# Proposed Garage removal and erection of new at, The Cottage, Low Street Site Location : North Wheatley, Retford, DN22 9DR.

## Policy Counter Statement – June 2023

In support of the erection of a new garage.

Drawing Title:  
 Existing and Proposed Site Plan

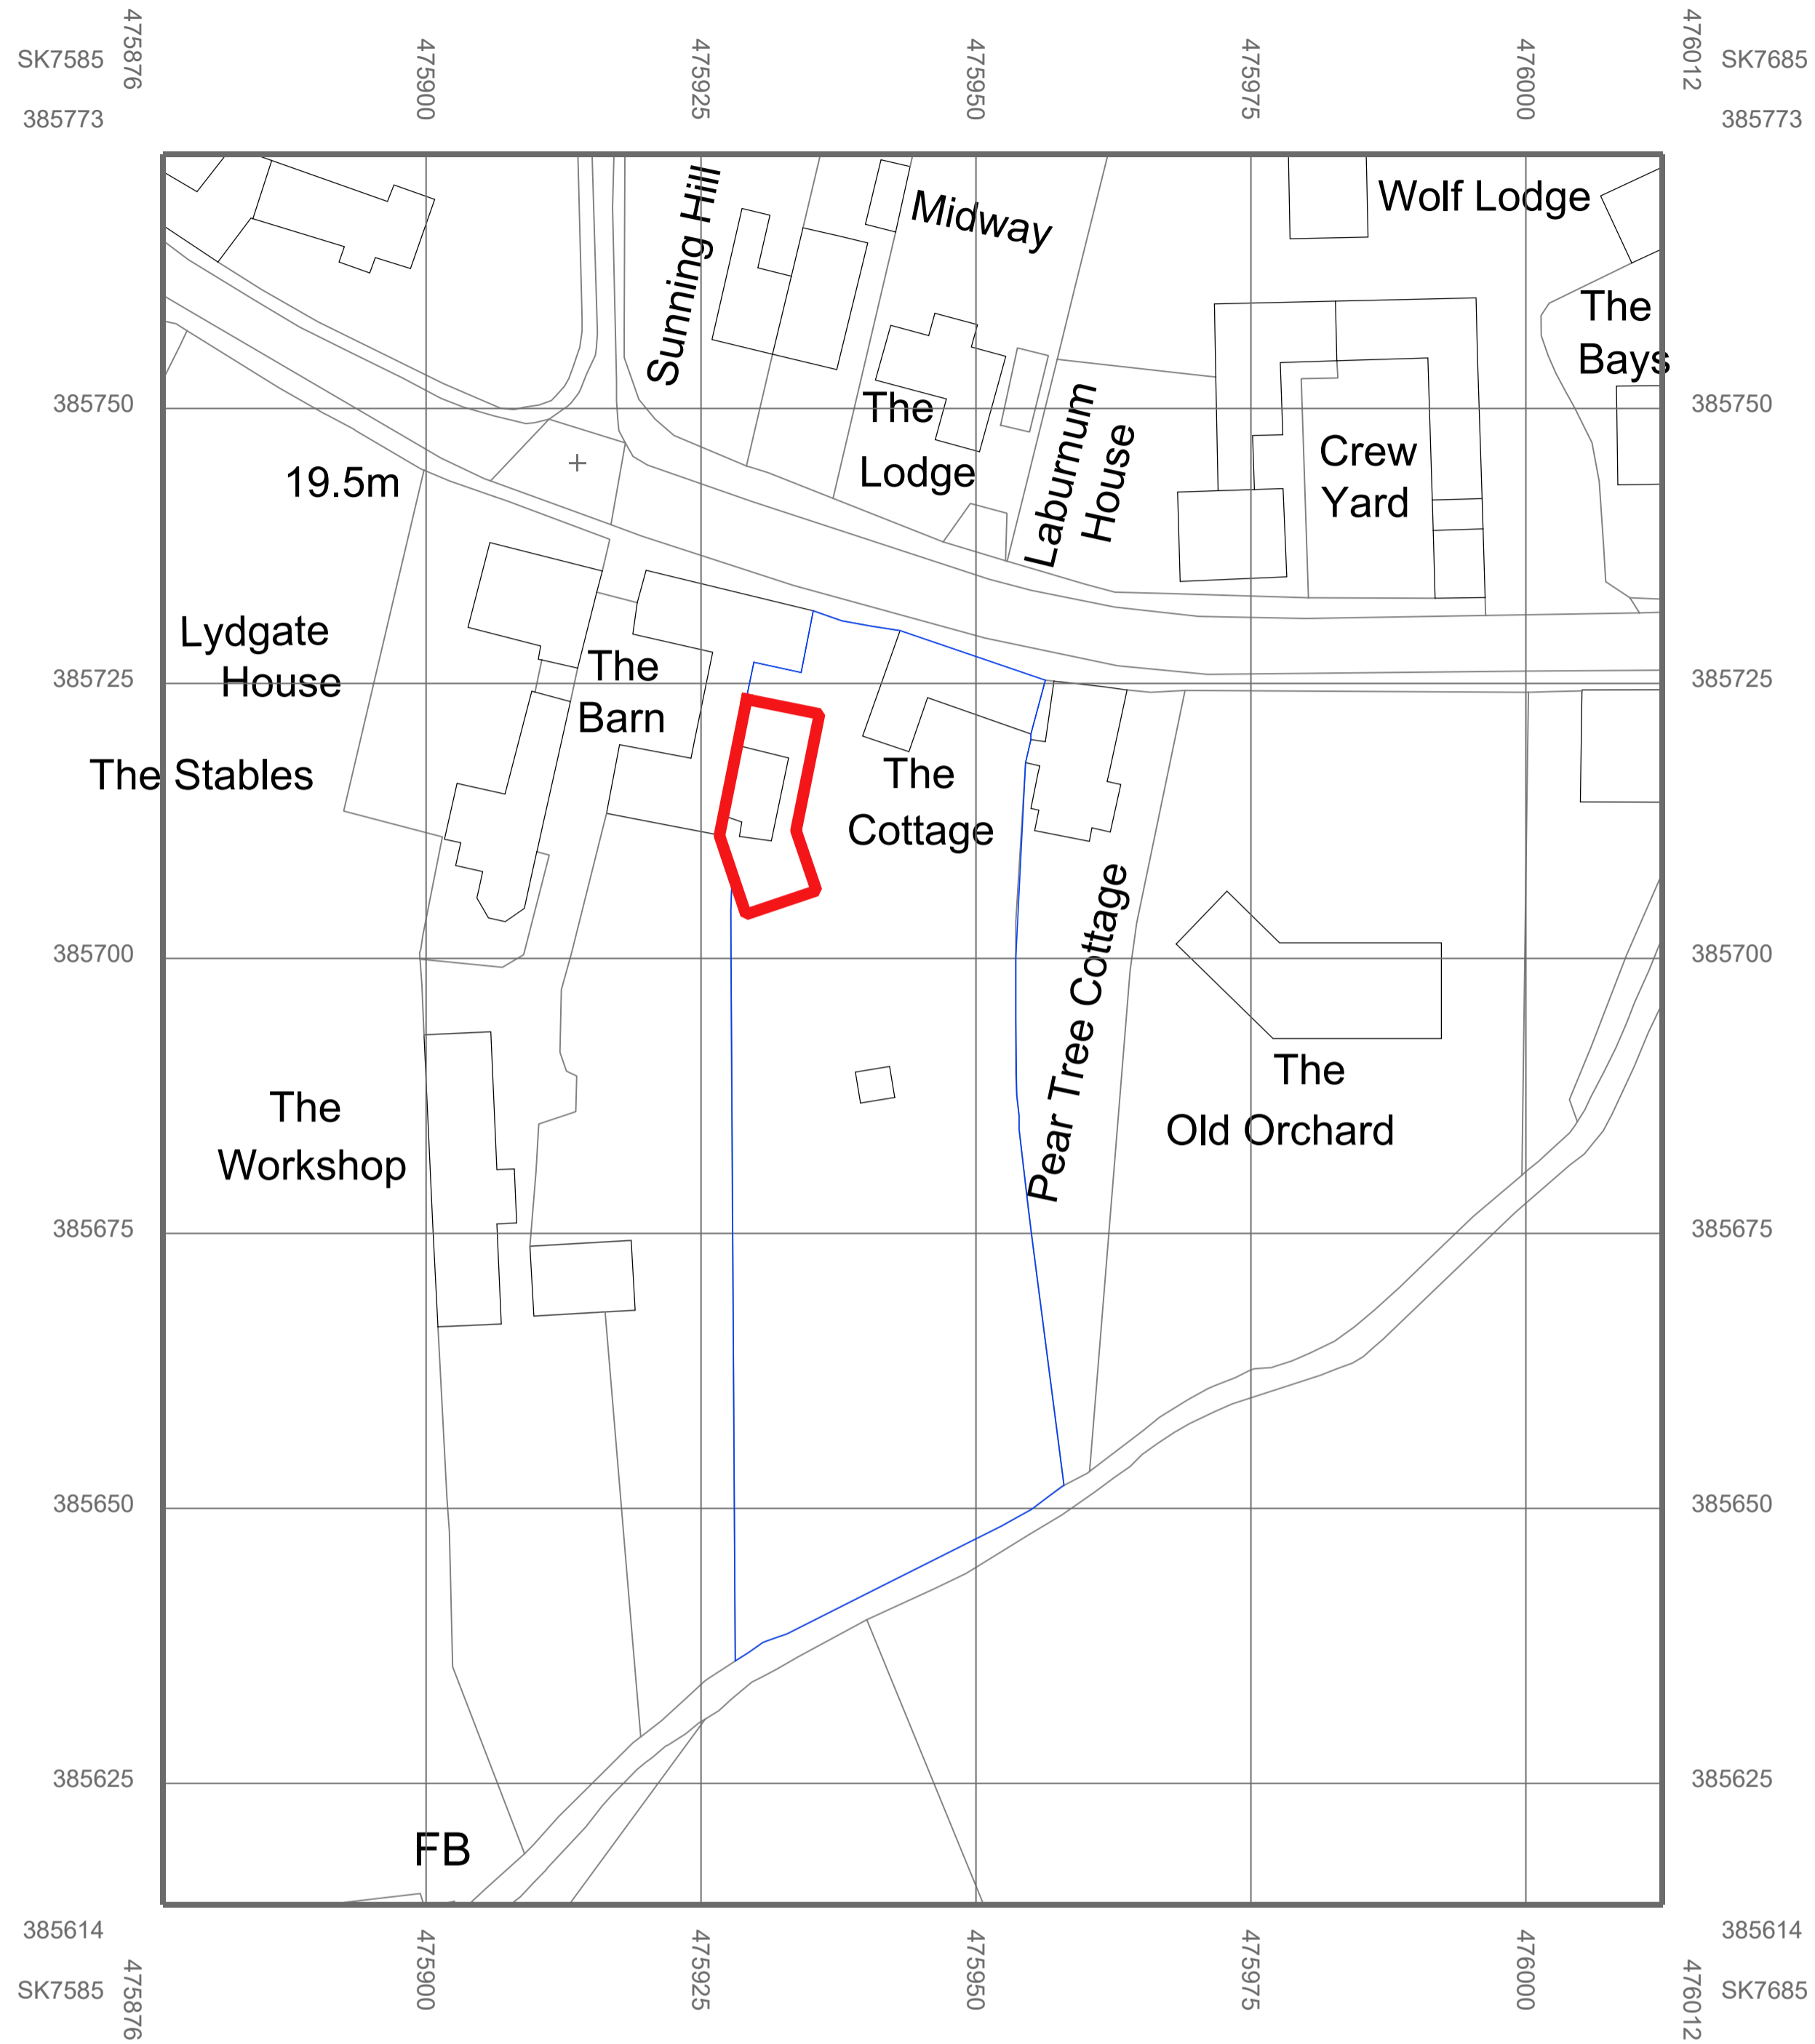
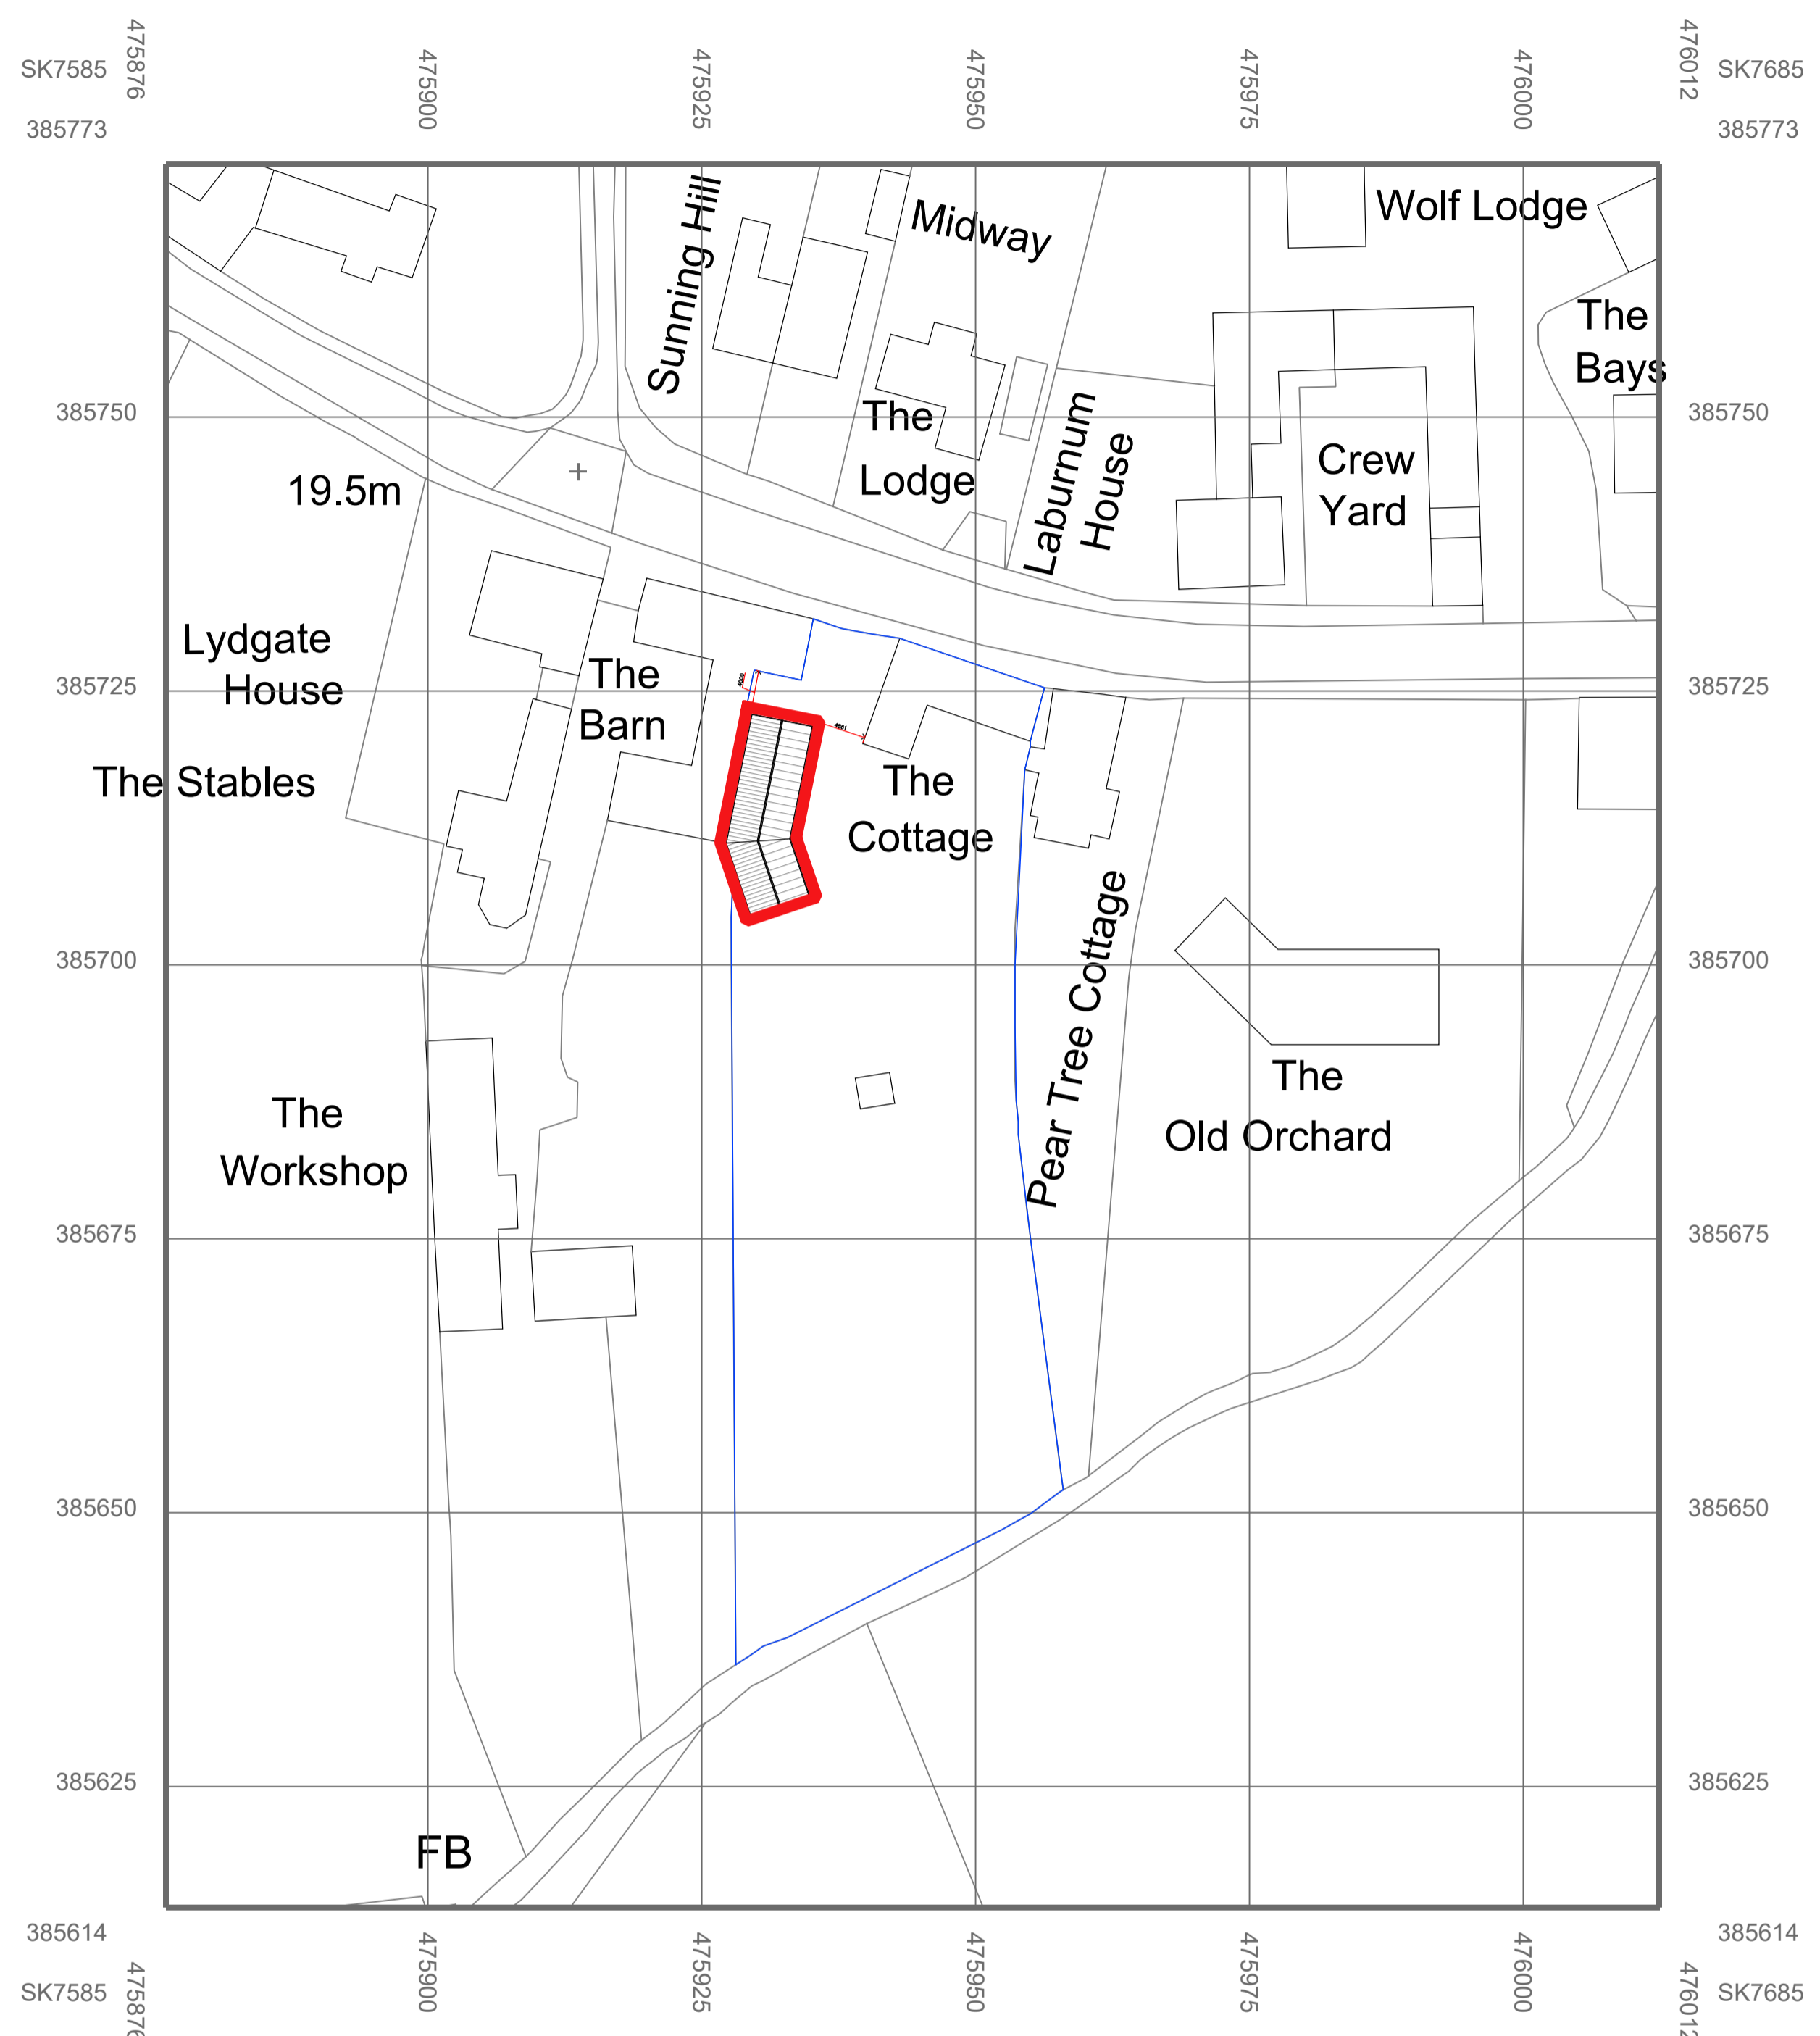
*The proposed garage, by virtue of its scale, position and proximity to the adjacent dwelling, 'The Barn', would have an unacceptable overshadowing and overbearing impact to the first floor south facing window of a habitable room within this neighbouring dwelling. This would unacceptably impose on the enjoyment of that dwelling for existing and future occupiers. The proposal is therefore contrary to Policy DM4 and the guidance within the NPPF.*

The position of the new garage was considered carefully, the intention was to site the proposed garage 3000mm away from the window / wall to The Barn, as mentioned in the refusal. However, as a compromise we have now increased this to 4000mm which reduces even further any impact the proposed garage may have onto the neighbouring property.
